Project: Bank Street Commercial Wharf

Report: Access Assessment Report

Reference No: 108077-Access-r1.1

Date: 25 May 2017

PROJECT NUMBER	CLIENT	PROJECT NORTH	DRAWING TITLE
160316	URBAN GROWTH NSW		ADMINISTRATION PLAN
	PROJECT NAME	SCALE	
	Bank St Commercial Wharf	1:100 @A3	
	S75W Application	STATUS	
		PRELIMINARY	
			DRAWING NUMBER
			REVISION
			S75W-07

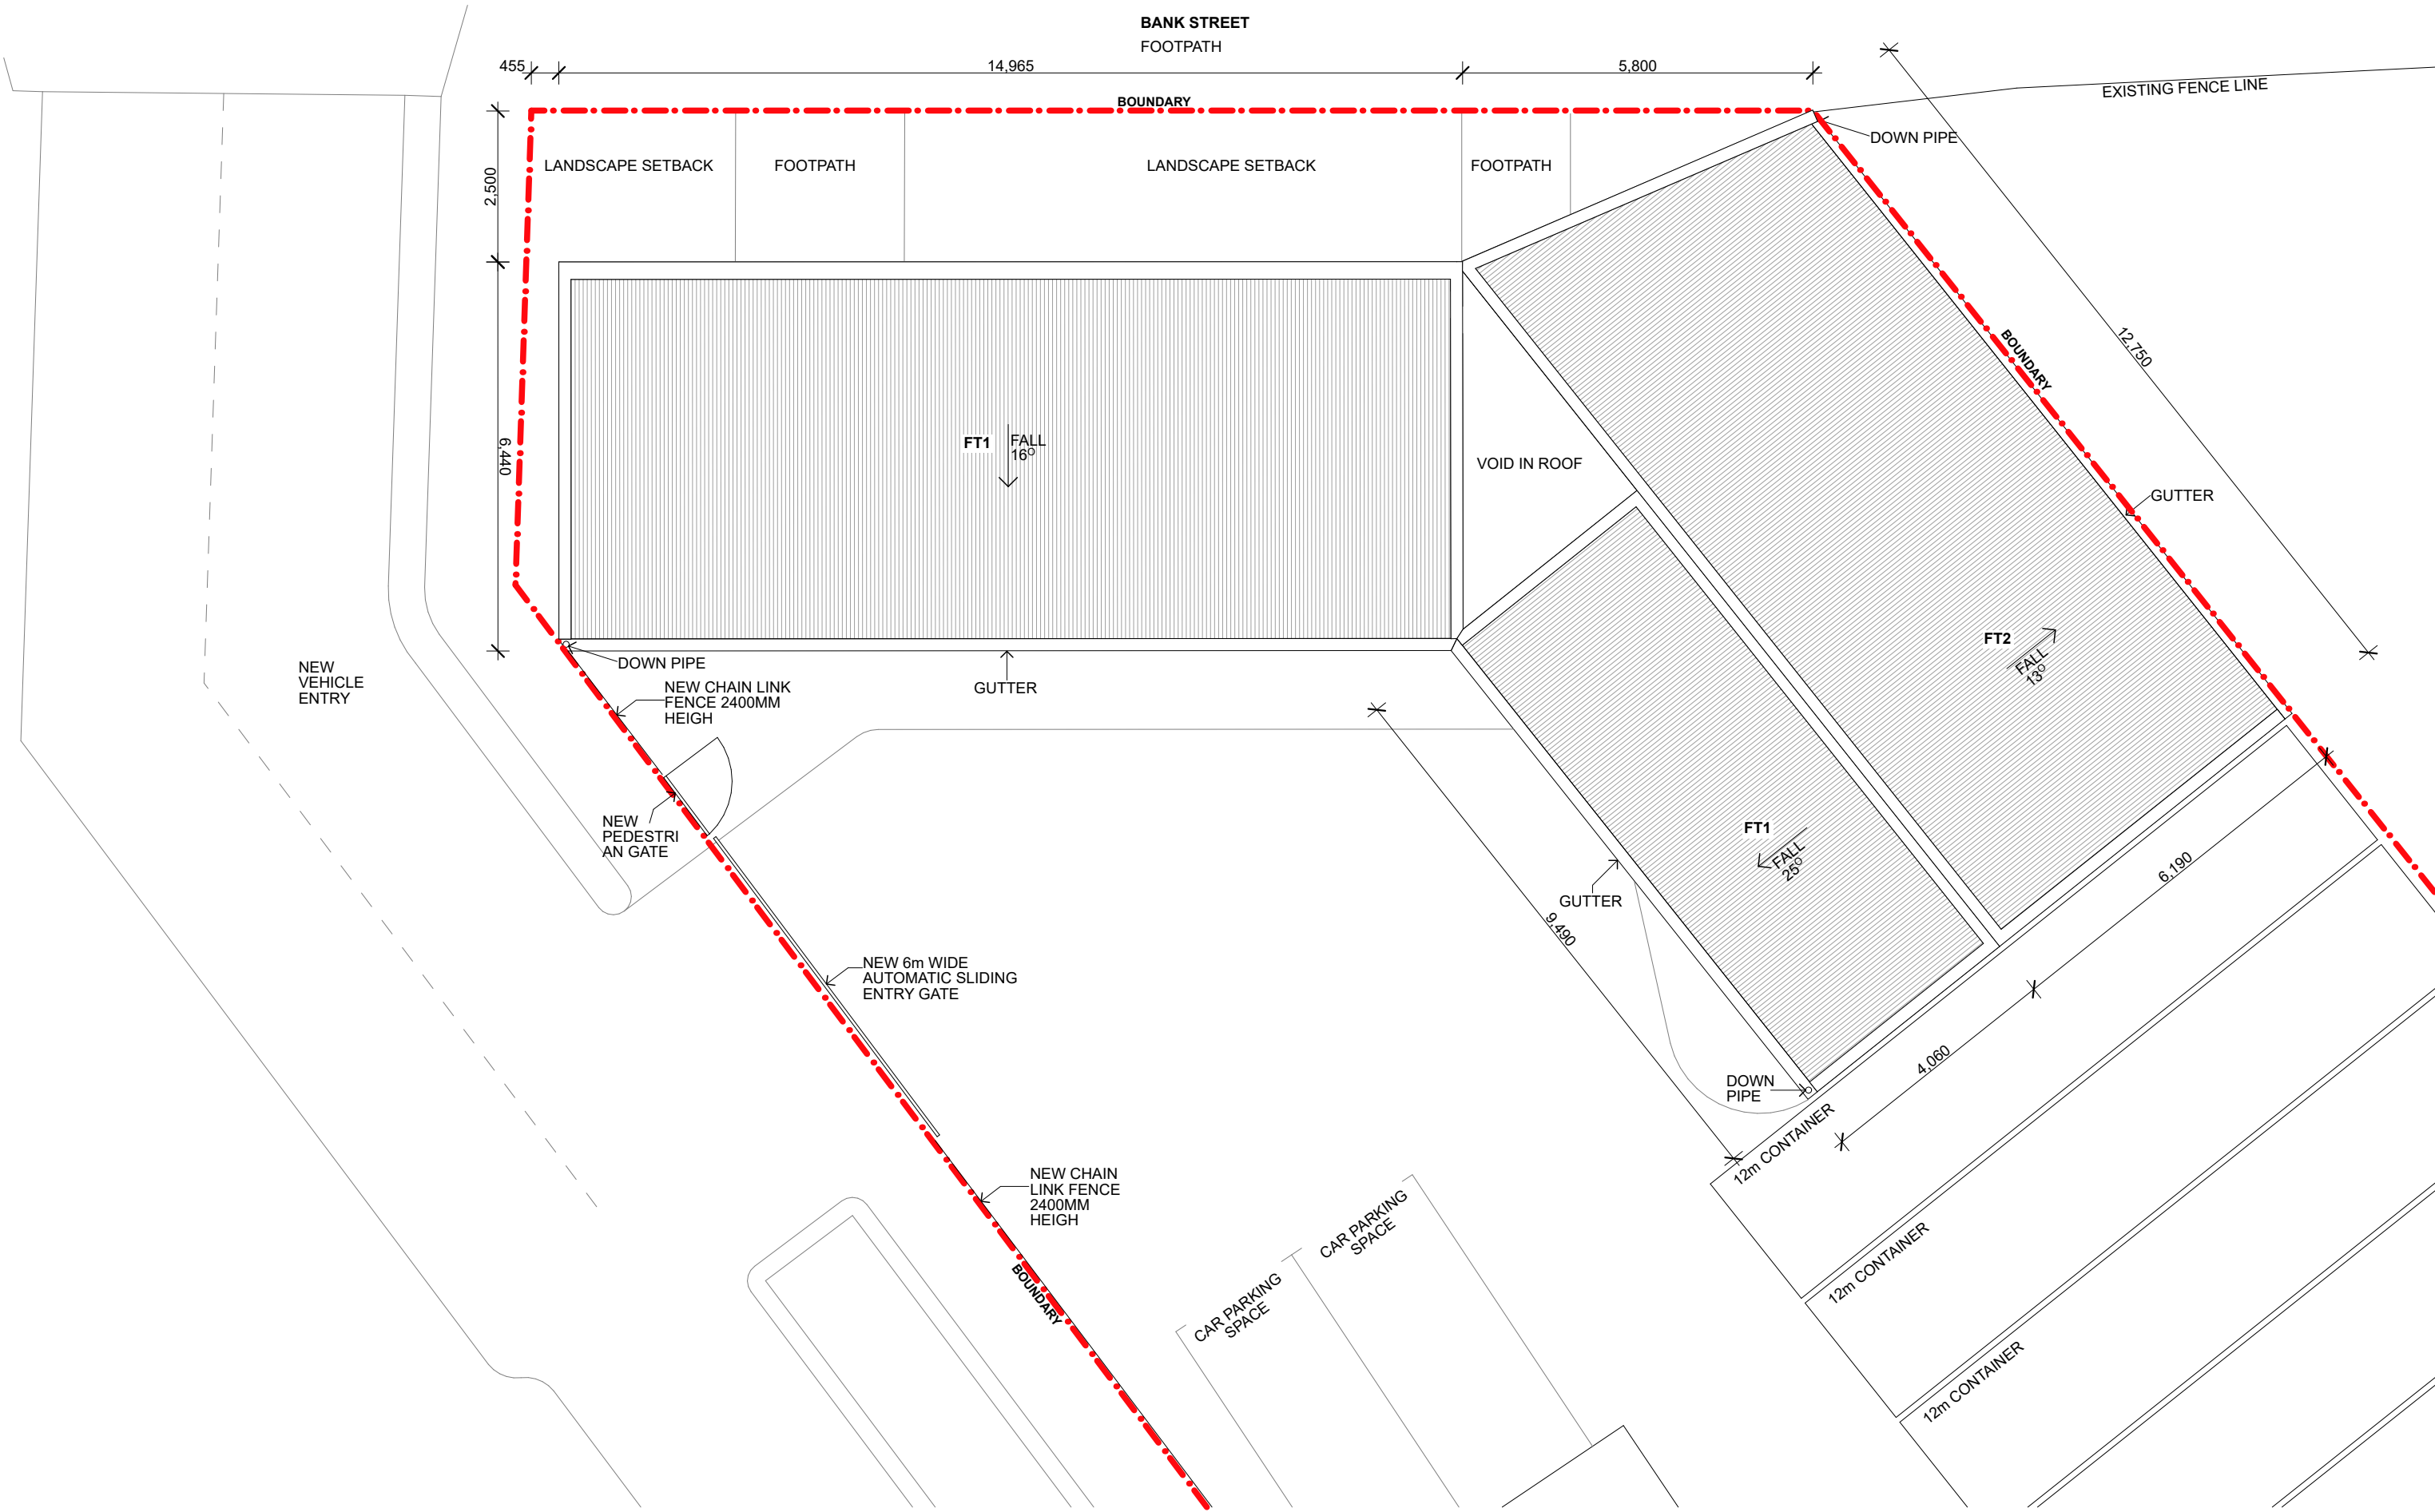
D3.3	Parts of Buildings to be Accessible	- Walkways and ramps must comply with clause 10 of AS 1428.1-2009. Ramp to office can readily achieve compliance. - Door circulation space to office entry door can comply with AS 1428.1 subject to modification of ramp to ensure handrail extensions do not	✓

SECTION D: ACCESS AND EGRESS		
	encroach into door latchside clearance (660mm). 1500mm x 1500mm turning space is required to the base of the ramp. This will require removal of FHR. - Door circulation space to all doors within the office can comply with AS 1428.1 subject to modification to reception area. - Accessways must have turning spaces (1540 mm x 2070 mm) within 2m of the end of the accessway and at maximum 20 m intervals along the accessway. Note: Turning spaces must be provided clear of fixtures and fittings. - Ground surfaces are assumed to be concrete or asphalt on the accessible path of travel to and from office and accessible parking space which can readily comply with AS 1428.1. If pavers or the like are proposed, ensure compliance with Clause 7 of AS 1428.1 is achieved. Note: The Access to Premises Standards do not provide the concessions provided in sub-clauses (g) and (h) in this clause, hence compliance with the Access to Premises Standards will require the floor covering (carpet) in the accessible areas to strictly comply with Clause 7.4.1(a) of AS1428.1-2009.
